# **Sheringham Shoal and Dudgeon Offshore Wind Farm Extension Projects**

Traffic and Transport Discussions with  
Norfolk County Council

Title:	
<b>Sheringham Shoal and Dudgeon Offshore Wind Farm Extension Projects Examination submission Traffic and Transport Discussions with NCC</b>	
PINS document no.:	
Document no.:	
Date:	Classification
<b>10.01.2023</b>	<b>Draft</b>
Prepared by:	
<b>Royal HaskoningDHV</b>	
Approved by:	Date:
<b>Sarah Chandler, Equinor</b>	<b>XX</b>

**Table 1-1 NCC Comments on SEP and DEP DCO documents and the Applicant's response**

▨ VEHICLE BODY SWEEP PATH (FORWARD GEAR)  
 — VEHICLE CHASSIS SWEEP PATH

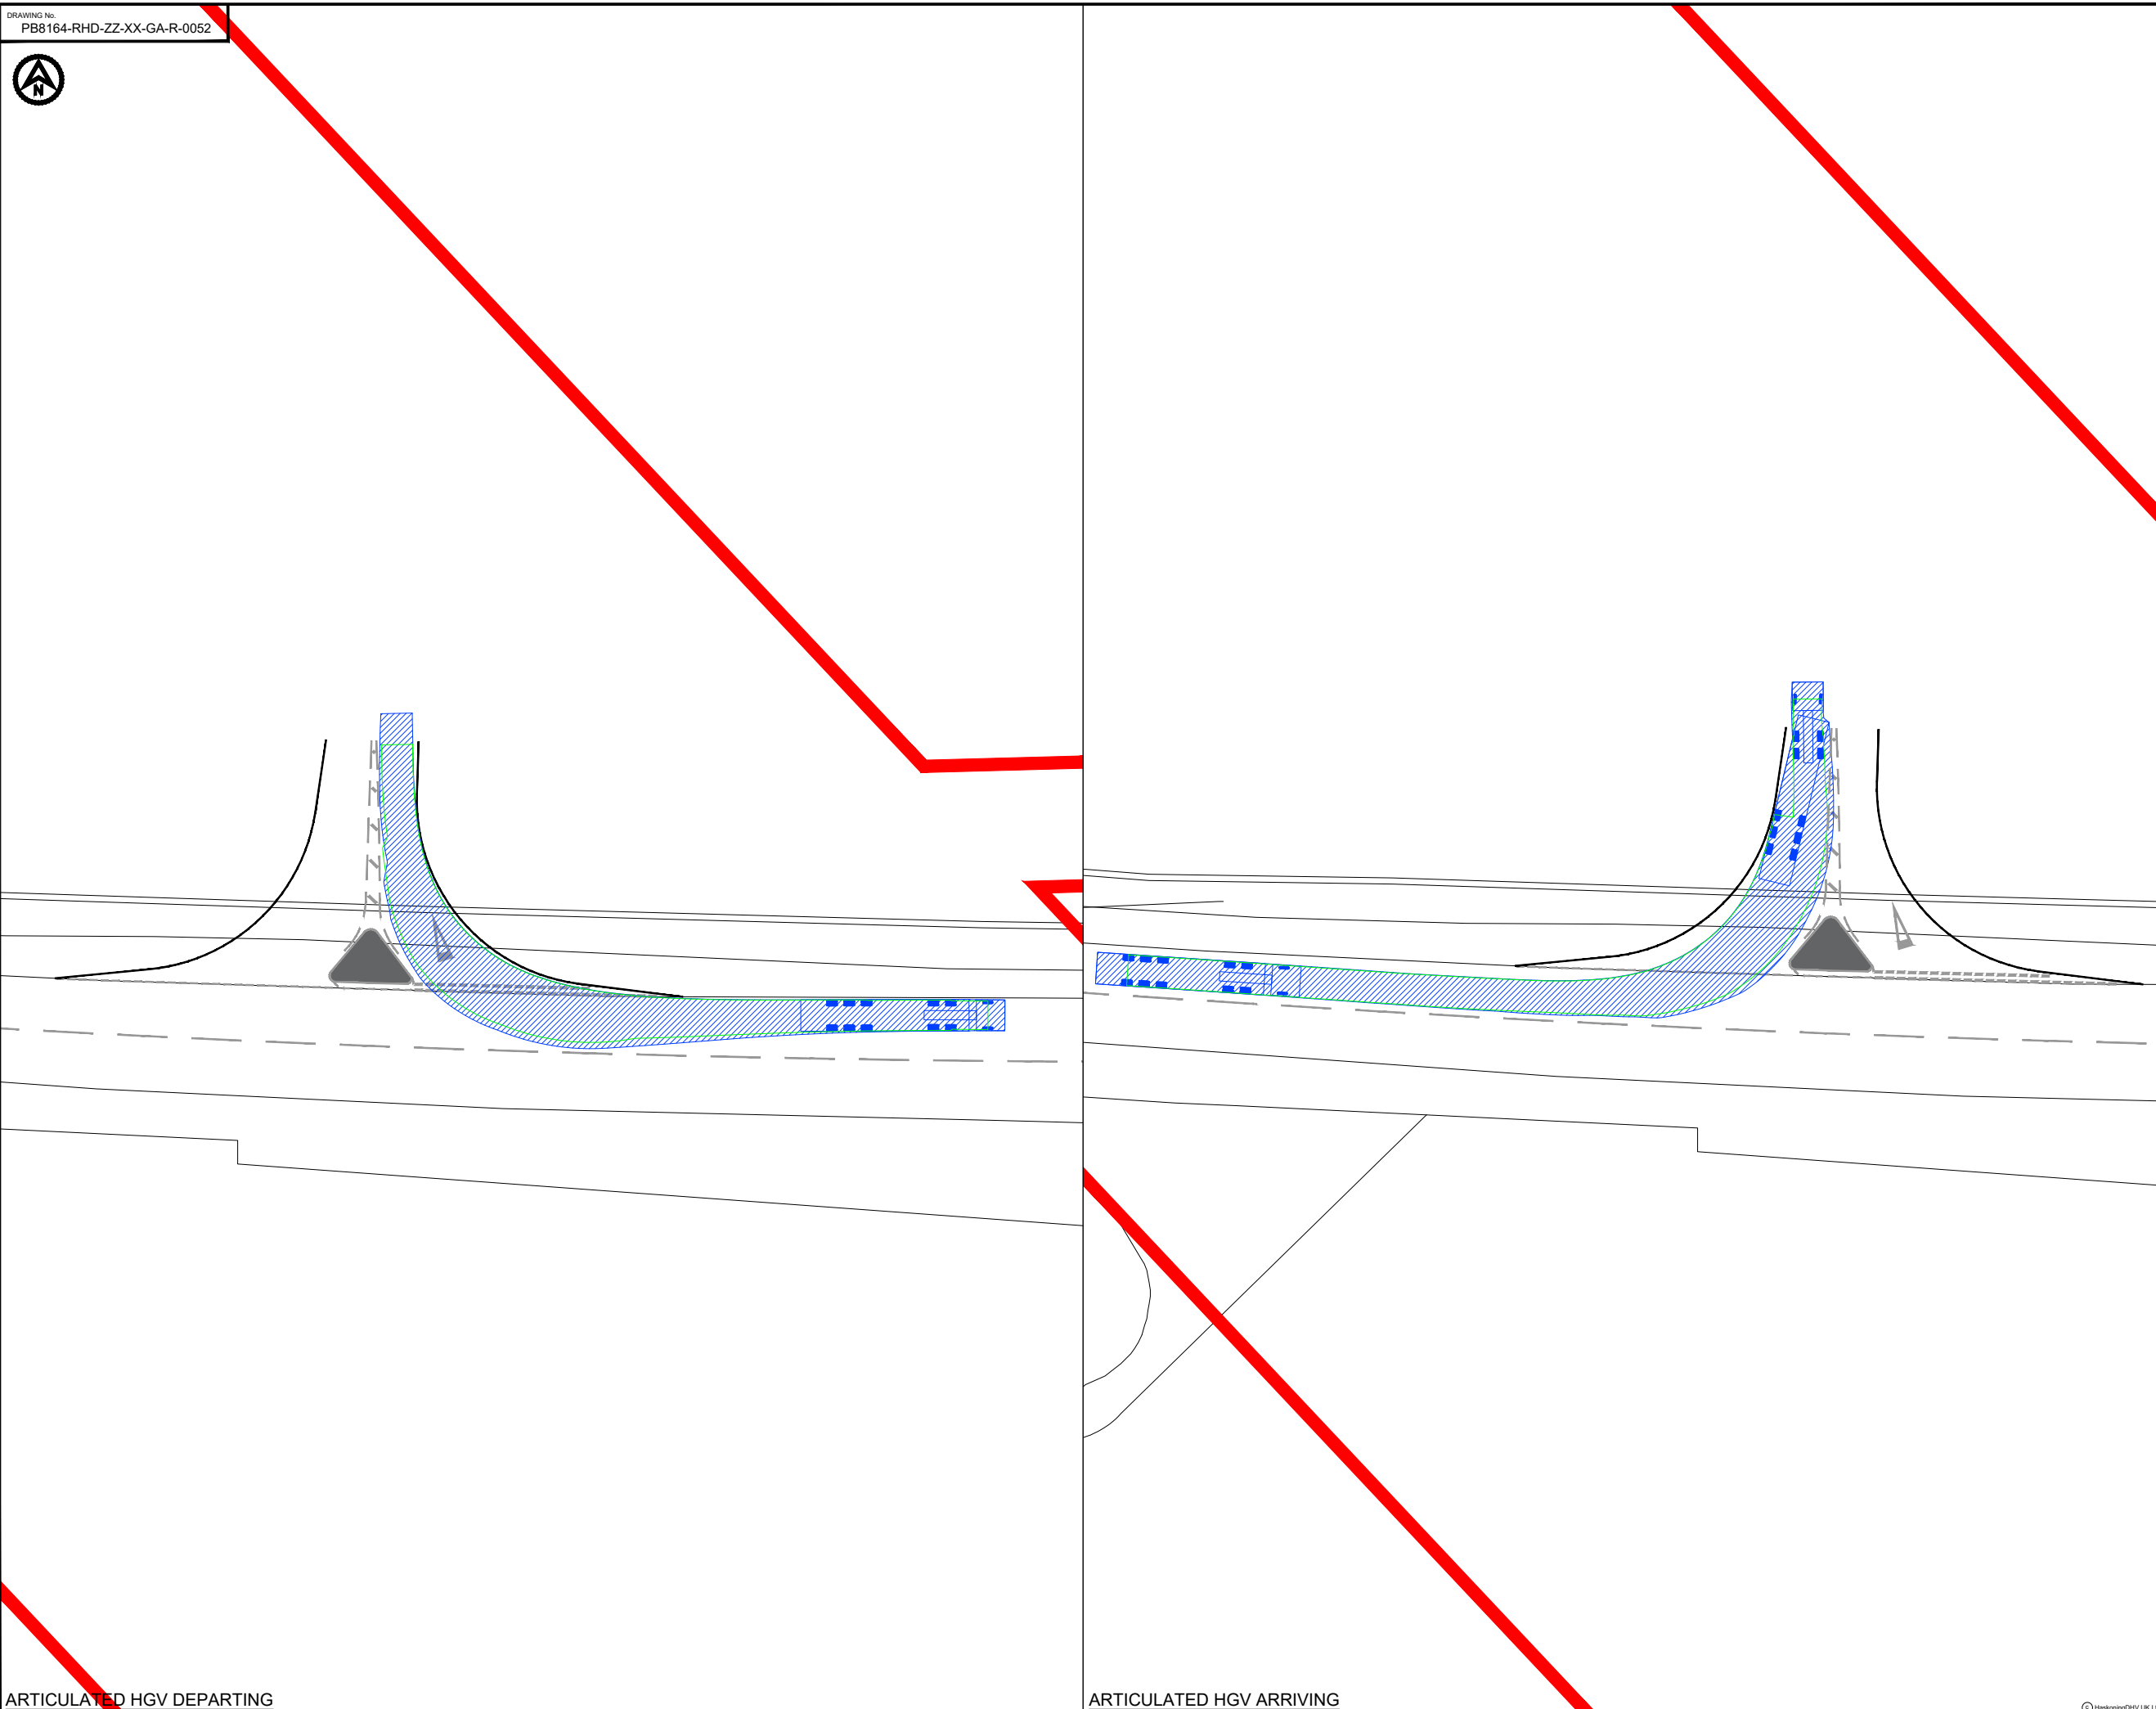
20		Sheet 28 Easton compound – need to factor in the Blind Lane closure for the A47 Tuddenham works	<p>Chapter 24 of the ES [APP-110] outlines that access to ACC49 will be provided from the unnamed road (link 93) that heads southwest from the A47 roundabout. No HGV traffic would be routed via Blind Lane. This commitment is contained within the OCTMP [APP-301] which is secured via Requirement 15 of the draft DCO [APP-024]. Figure 1 of the OCTMP contains the permitted HGV routes and it can be identified that no HGVs are permitted via Blind Lane and that HGVs will instead be required to use link 93. Section 2.3 of the OCTMP sets out how the routing of HGVs will be controlled.</p> <p>Annex 19 of the TA [APP-269] outlines the forecast numbers of peak daily vehicle trips that could travel to ACC49. This identifies that at peak, there could be up to 37 HGV trips per day, equivalent to two arrivals and two departures an hour. In addition, Annex 23 of the TA [APP-269] identifies that there could be a peak of up to 40 LV trips per day, equivalent to 20</p>	NCC confirmed that they are content with the clarification provided and that the measures outlined within the OCTMP to manage traffic movements are appropriate.
